Our ref: XA/2025/100325/01-L01

A46 Newark Bypass – Development Consent Order (DCO) Application

A46 from Farndon Roundabout to Winthorpe Roundabout, near Newark-On-Trent

Deadline 8 (03 April 2025)

**Figure 3-5 Cross section A-A through embankment**

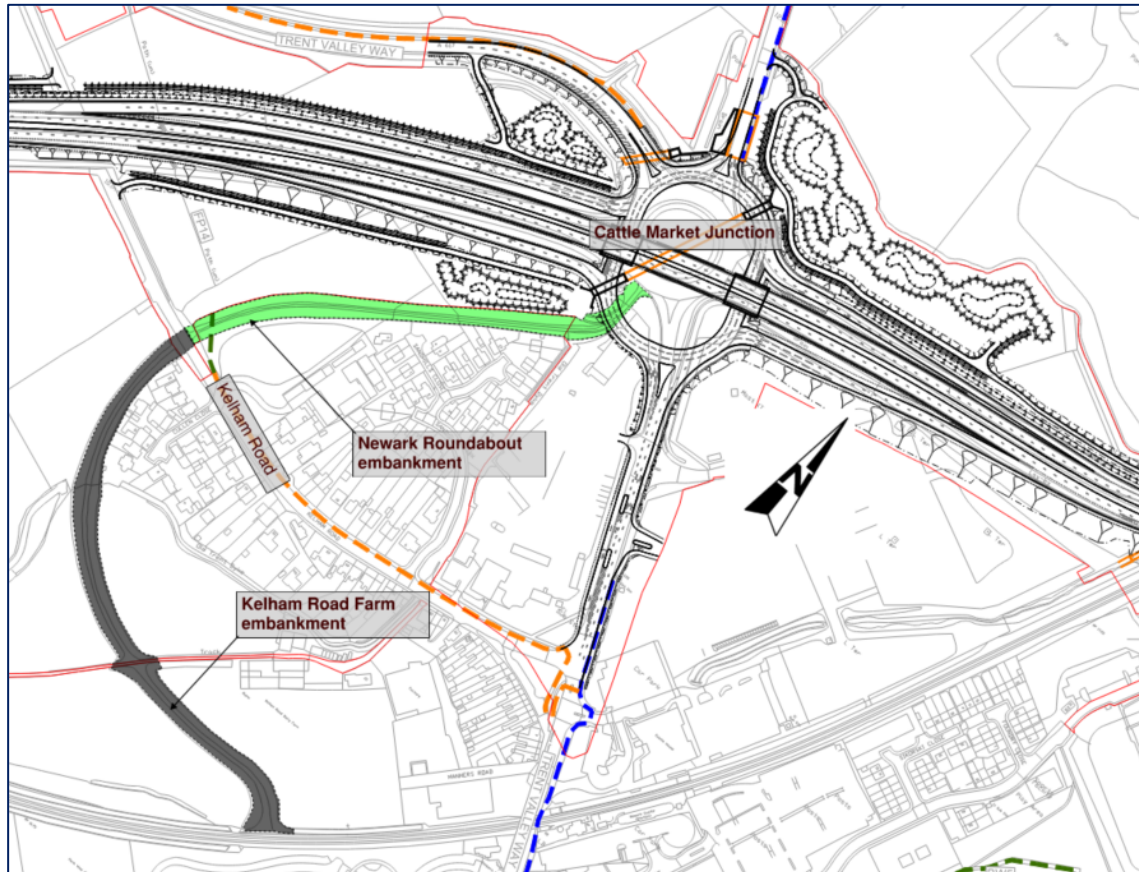
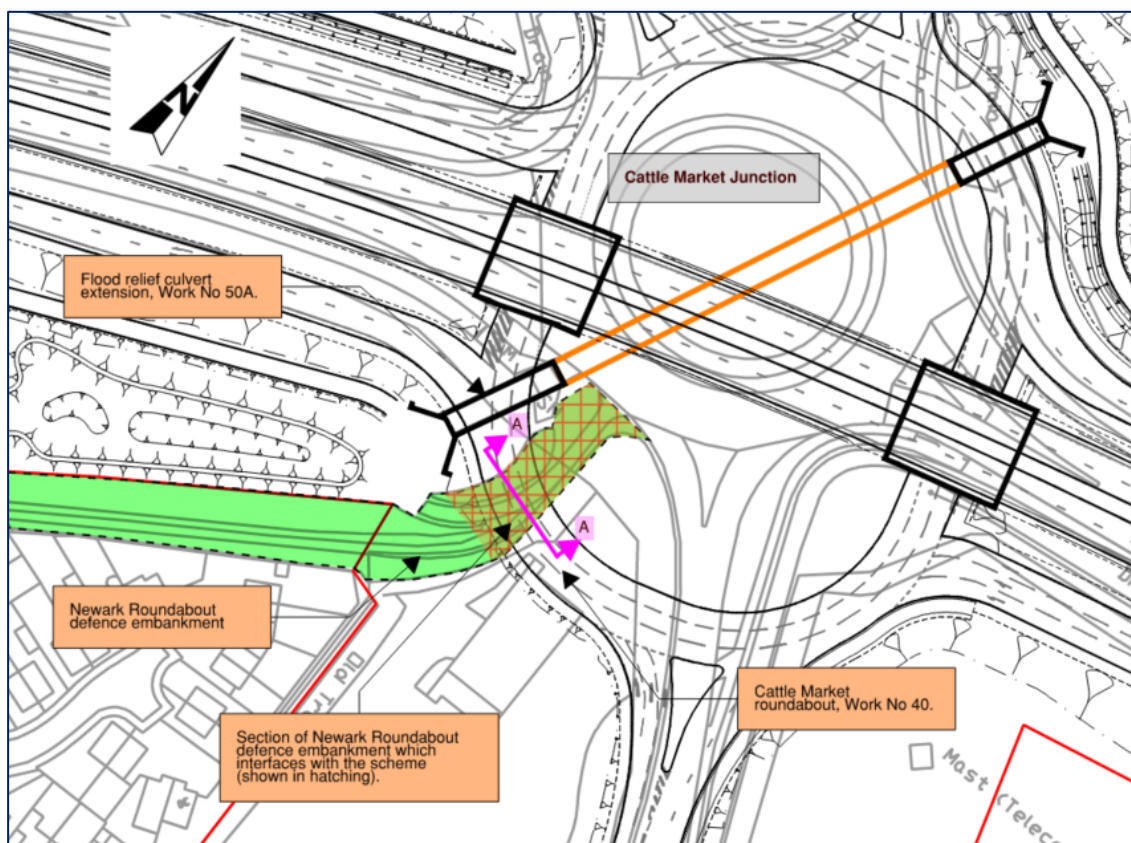
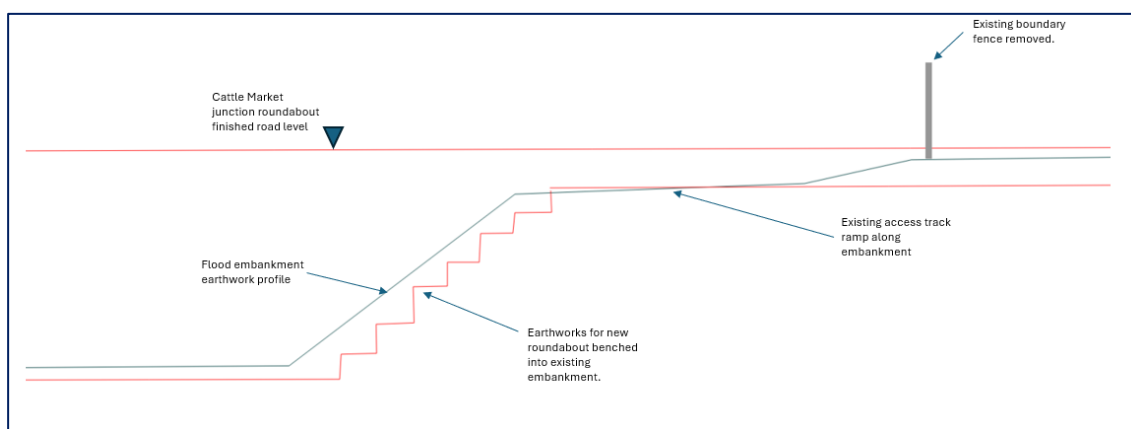
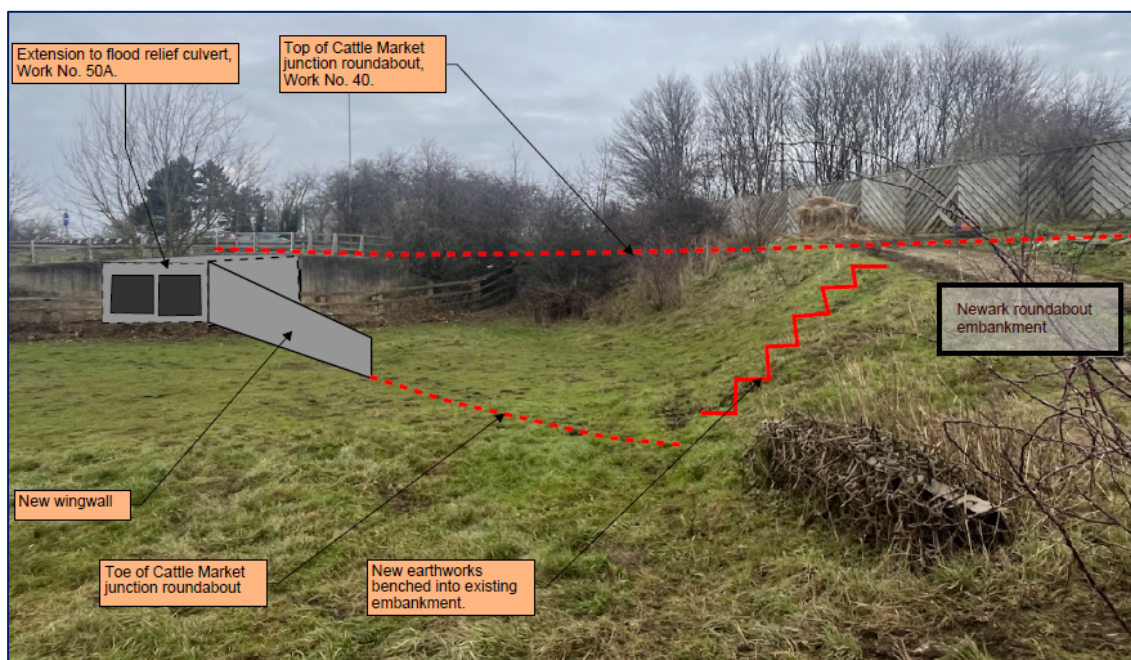
7.67 Cross sections requested by the Environment Agency - Rev 2 [REP7-098 / REP7-099]

The updated cross sections document satisfactorily addresses our outstanding concerns regarding the Scheme's tie-in with Kelham Road flood defence embankment at the Newark Roundabout / Cattle Market Junction.

In particular, the Applicant has now submitted detailed drawings, cross-sections and additional details of the mitigation measures they will be putting in place to protect the stability and level of protection the flood defence embankment provides.

As such, we have no outstanding concerns regarding the Scheme's interaction with Environment Agency maintained flood defences.
